**Bayswater Power Station Upgrade (SSD-9697)  
Request for additional information**

I refer to Assessment for the Bayswater Power Station Upgrade (SSD-9697). We require additional information noted below:

Figure 1: Site Location

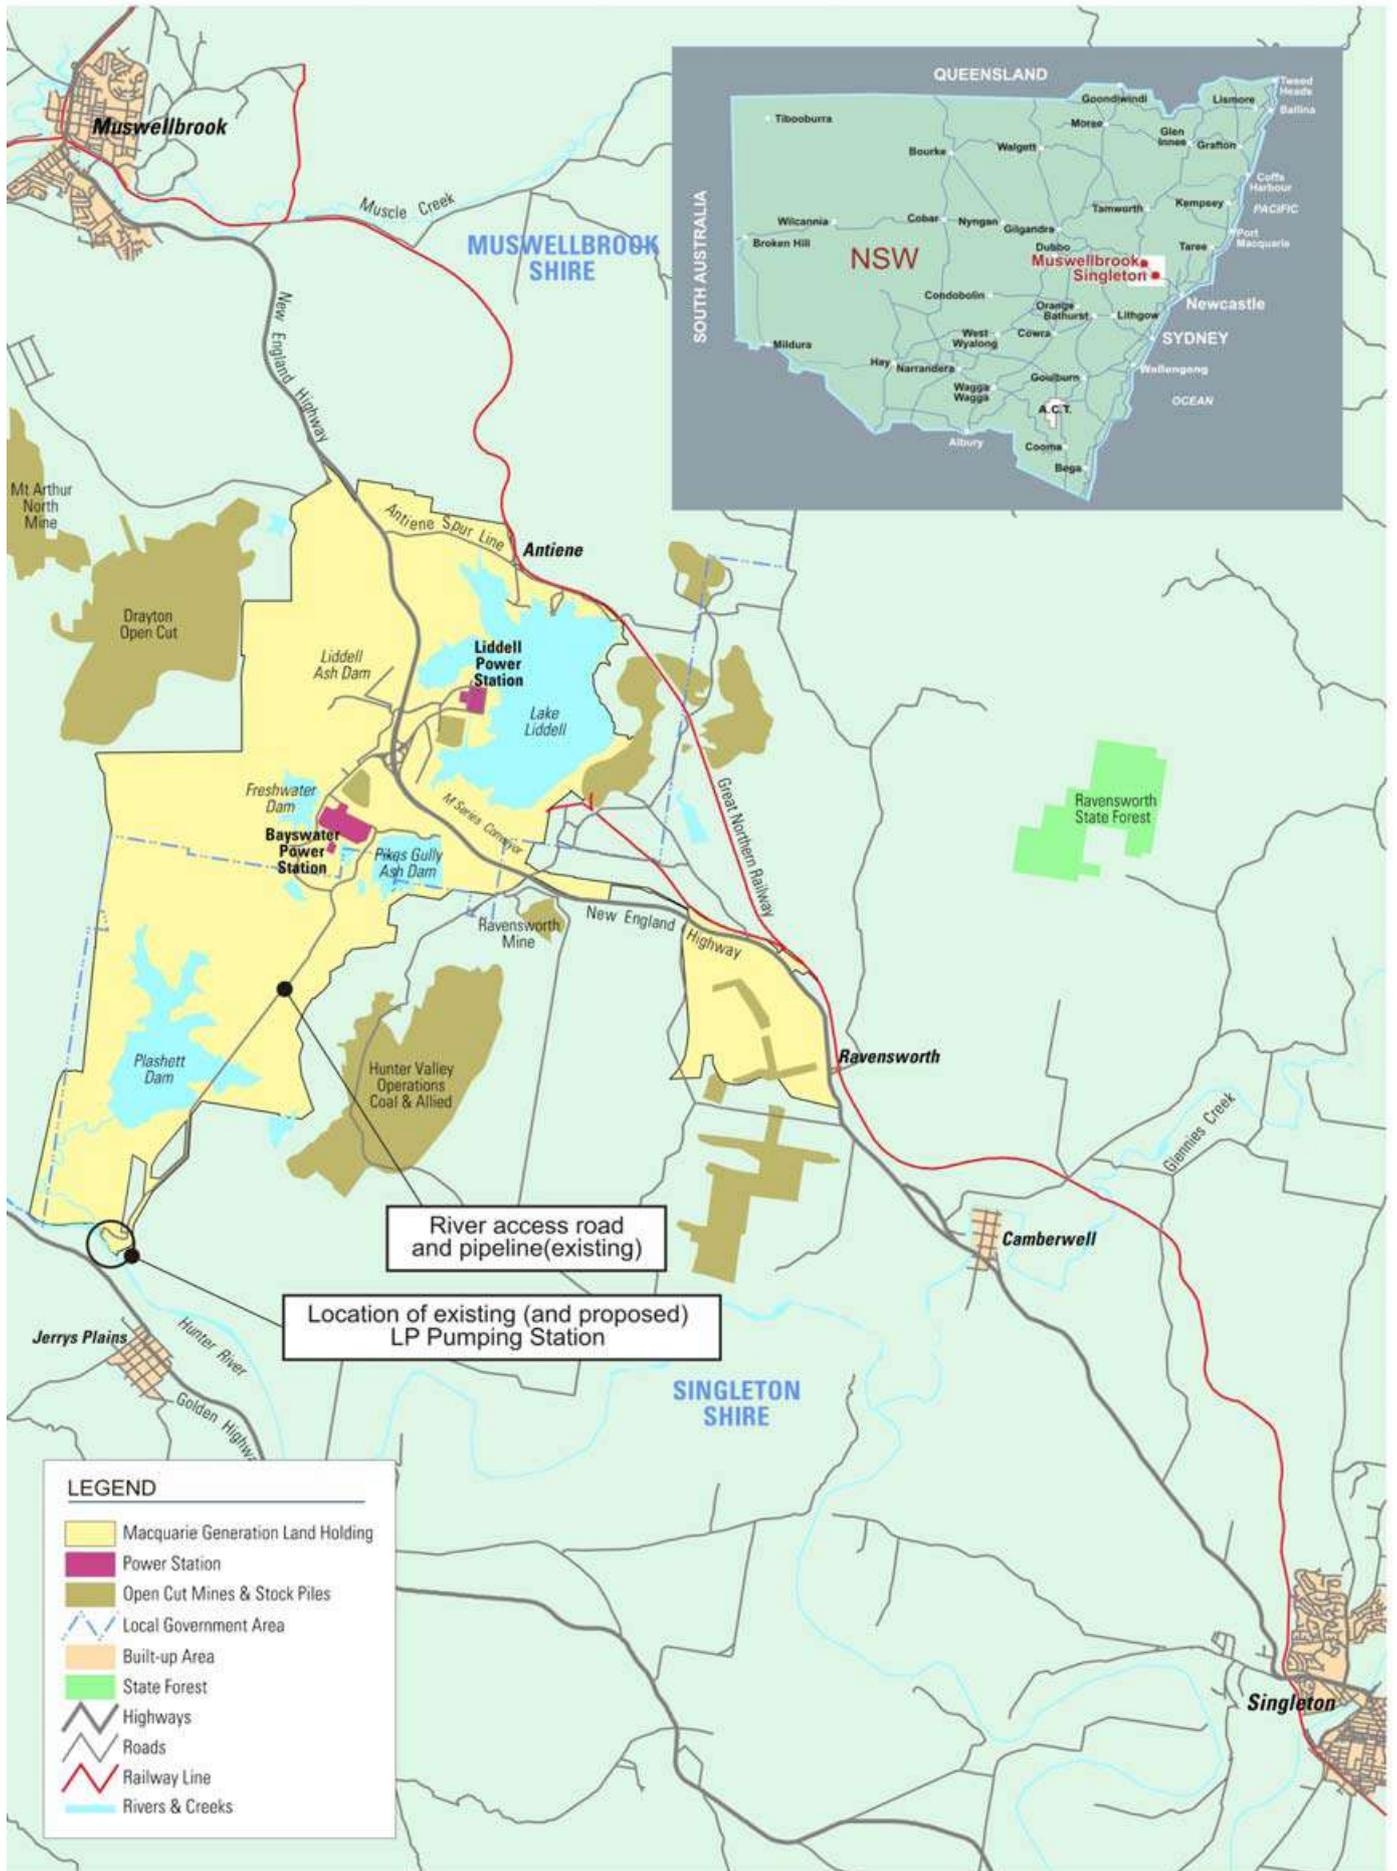
- A copy of the Operational Environmental Management Plan and Ecology Management Plan for DA 06\_0259 – Bayswater Power Station Water Pumping Station Upgrade; and
- A revised version of Figure 1-1 in the EIS with additional detail to show key features and localities.
